16 August 2011

Our Ref: HJA/EH/15/10

Re: Planning Application – West Beach Café

PLAN OF PROPOSED W.C.'s AND STORAGE UNIT LOCATED AT WEST BEACH CAFE, LITTLEHAMPTON. BN17 5DE.

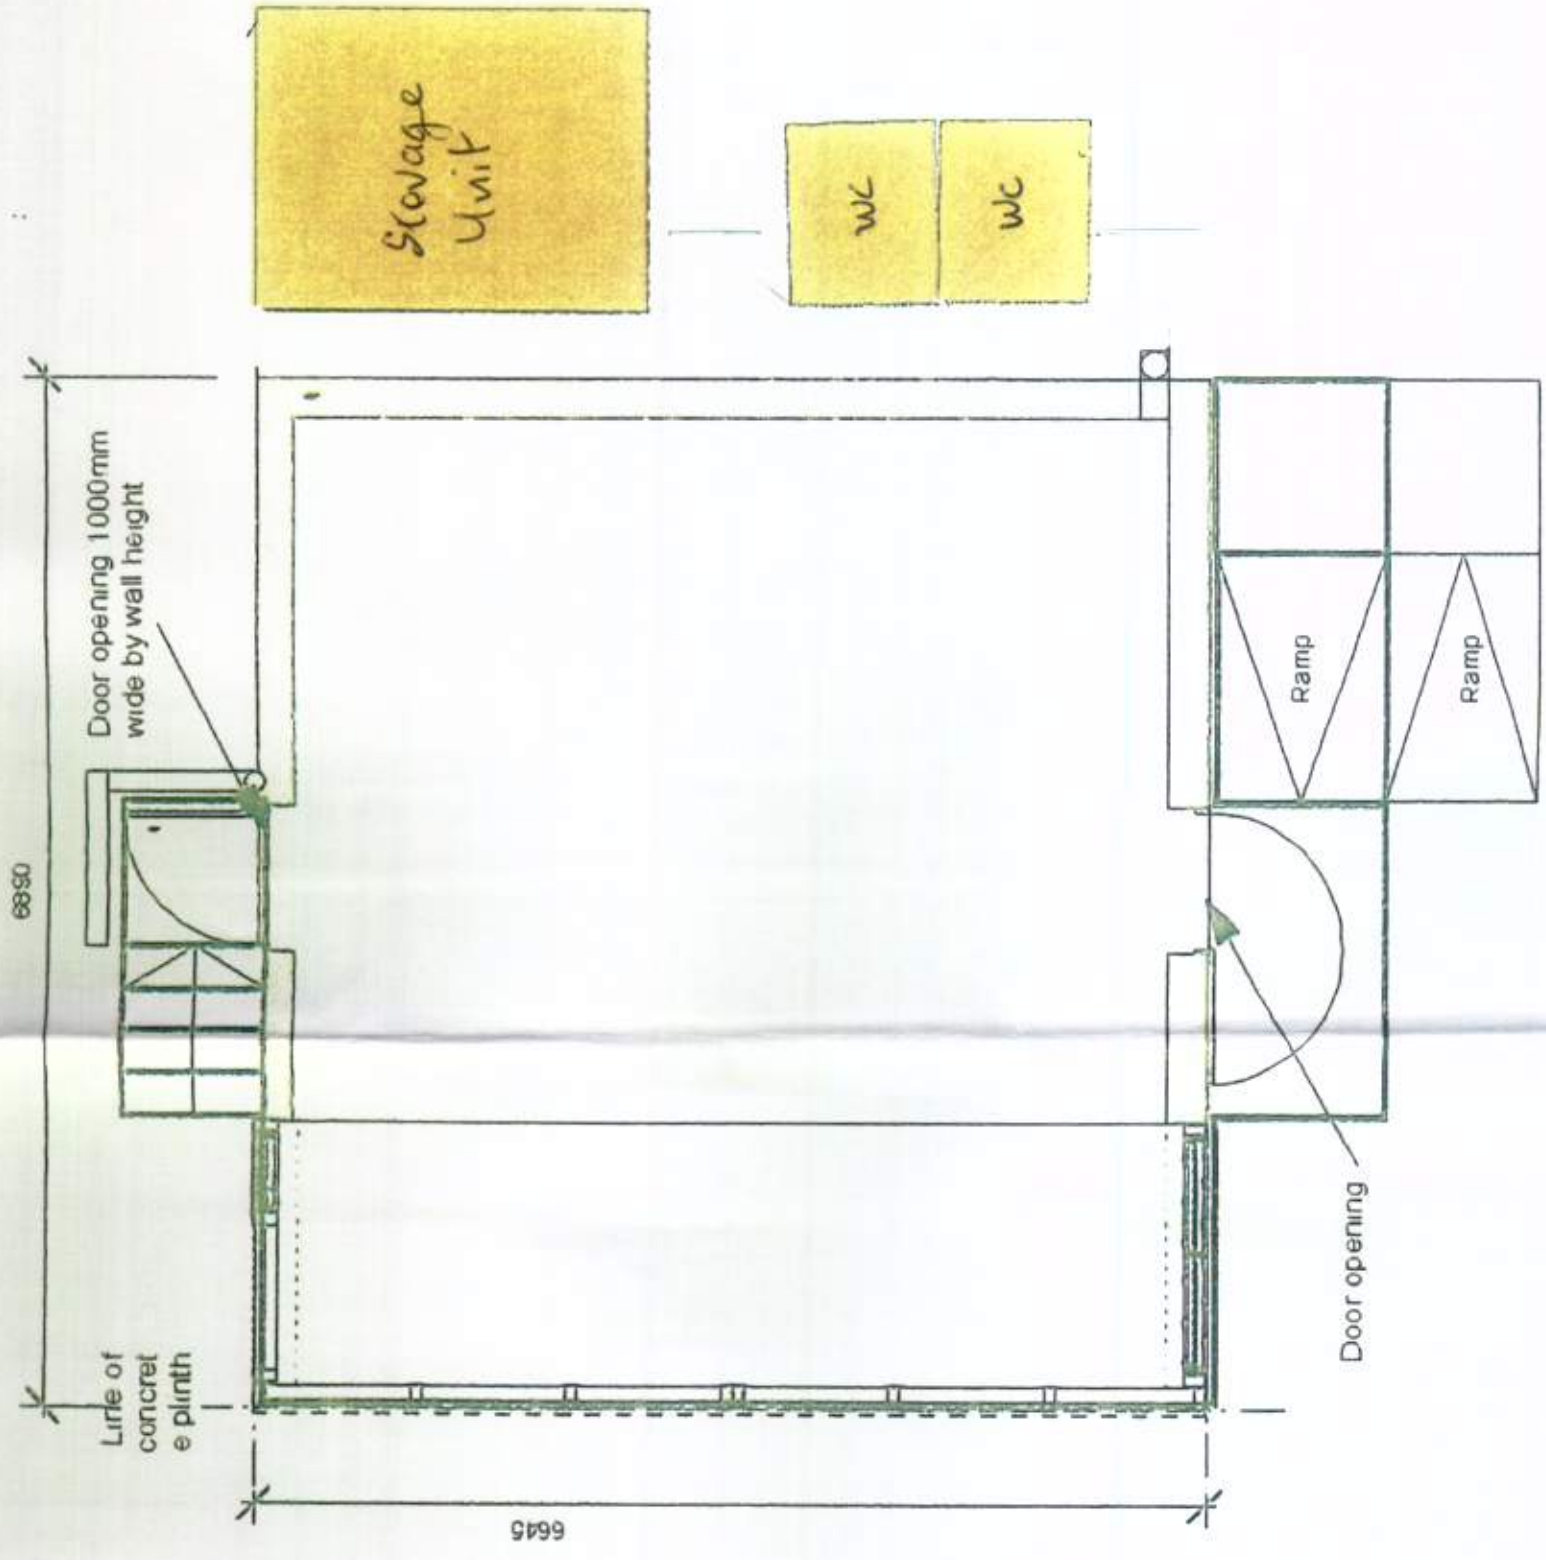
We note that the planning application for the Café has been deferred to allow you to submit an amended plan to include a waste storage area. Please clarify if the amended plan will also contain provision for a disabled toilet.
